NSW RURAL FIRE SERVICE

Your Ref: SD 7015
Our Ref: D16/0271

Resource Recovery Facility, West Nowra SSD 7015

The Service provides the following recommended conditions:

Job Number 21-22855
Revision A
Date SEPT 2015
Figure 6.1
dntel@ghd.com W www.ghd.com

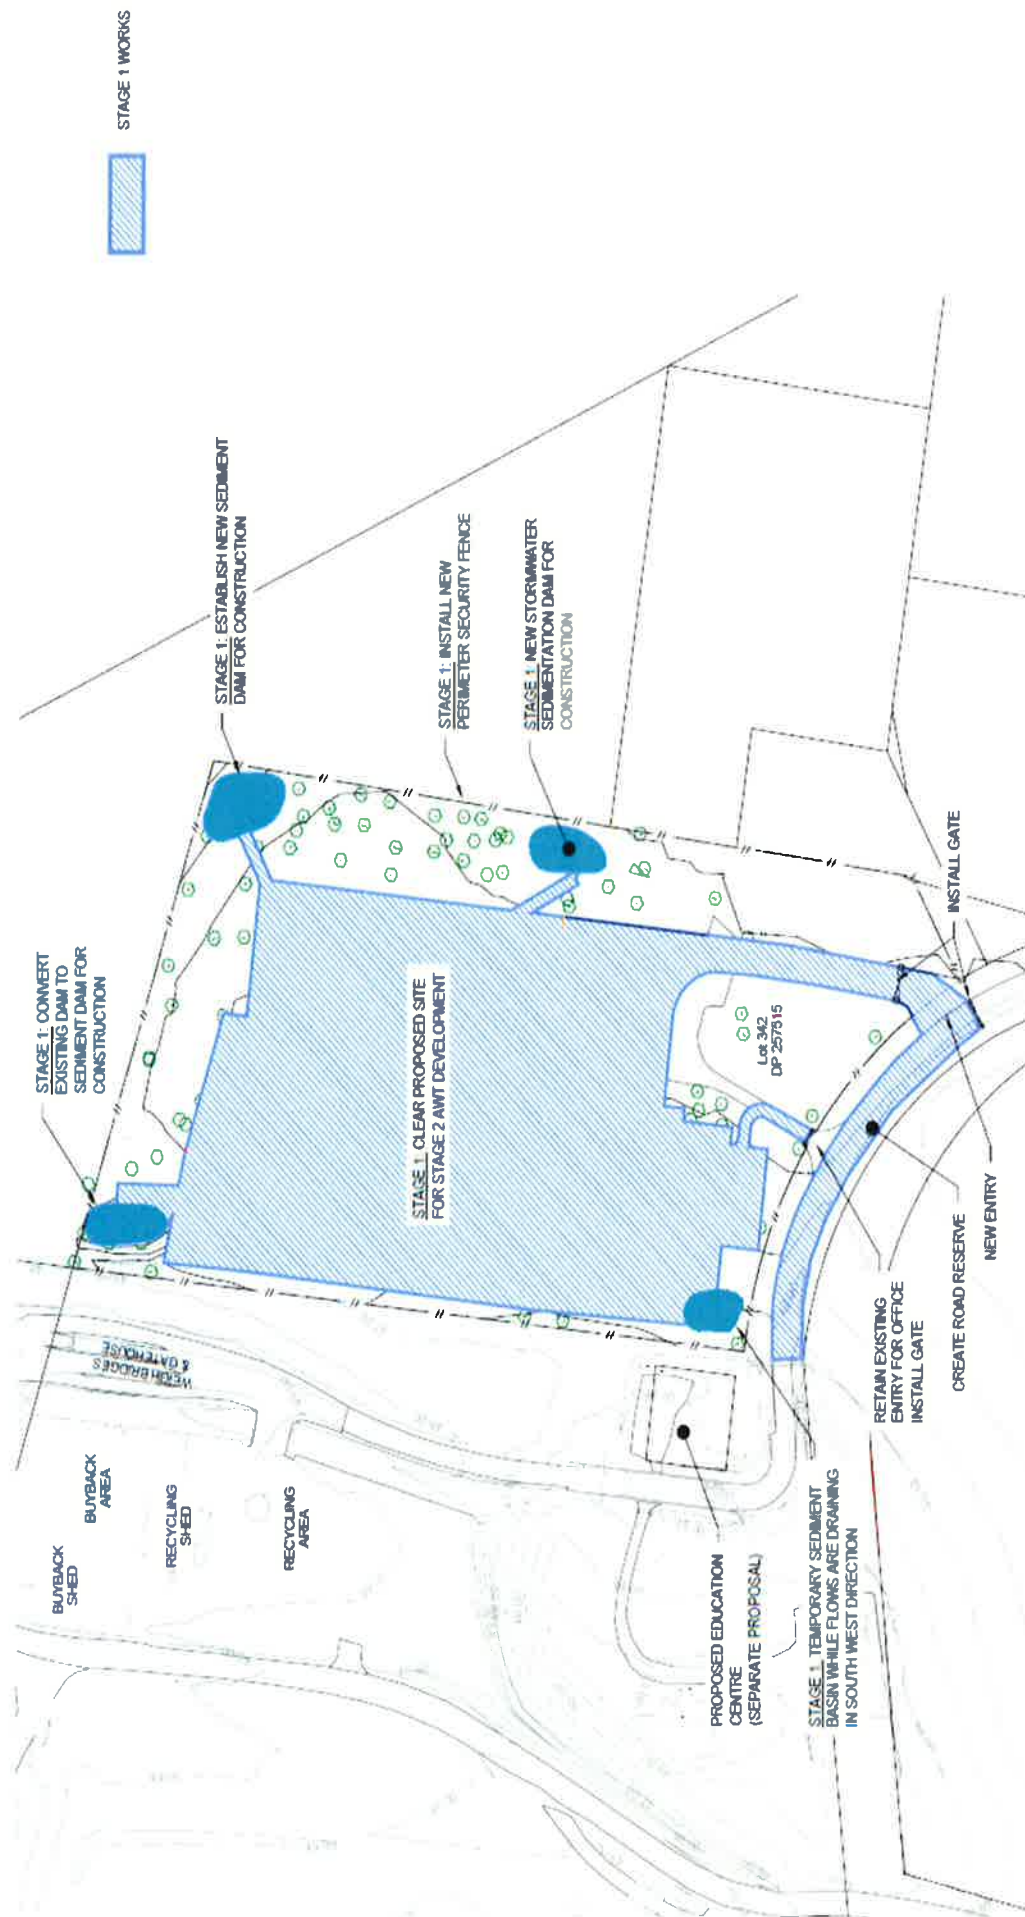
1. The development proposal is to comply with the proposed master plan identified on the drawing prepared by GHD numbered 21-22855 dated September 2015.

2. At the commencement of buildings works and in perpetuity, an asset protection zone (APZ) 30m wide shall be created and maintained along the northern, eastern and southern boundaries of the site. The APZ shall be maintained as outlined within section 4.1.3 and Appendix 5 of 'Planning for Bush Fire Protection 2006' and the NSW Rural Fire Service's document 'Standards for asset protection zones'.
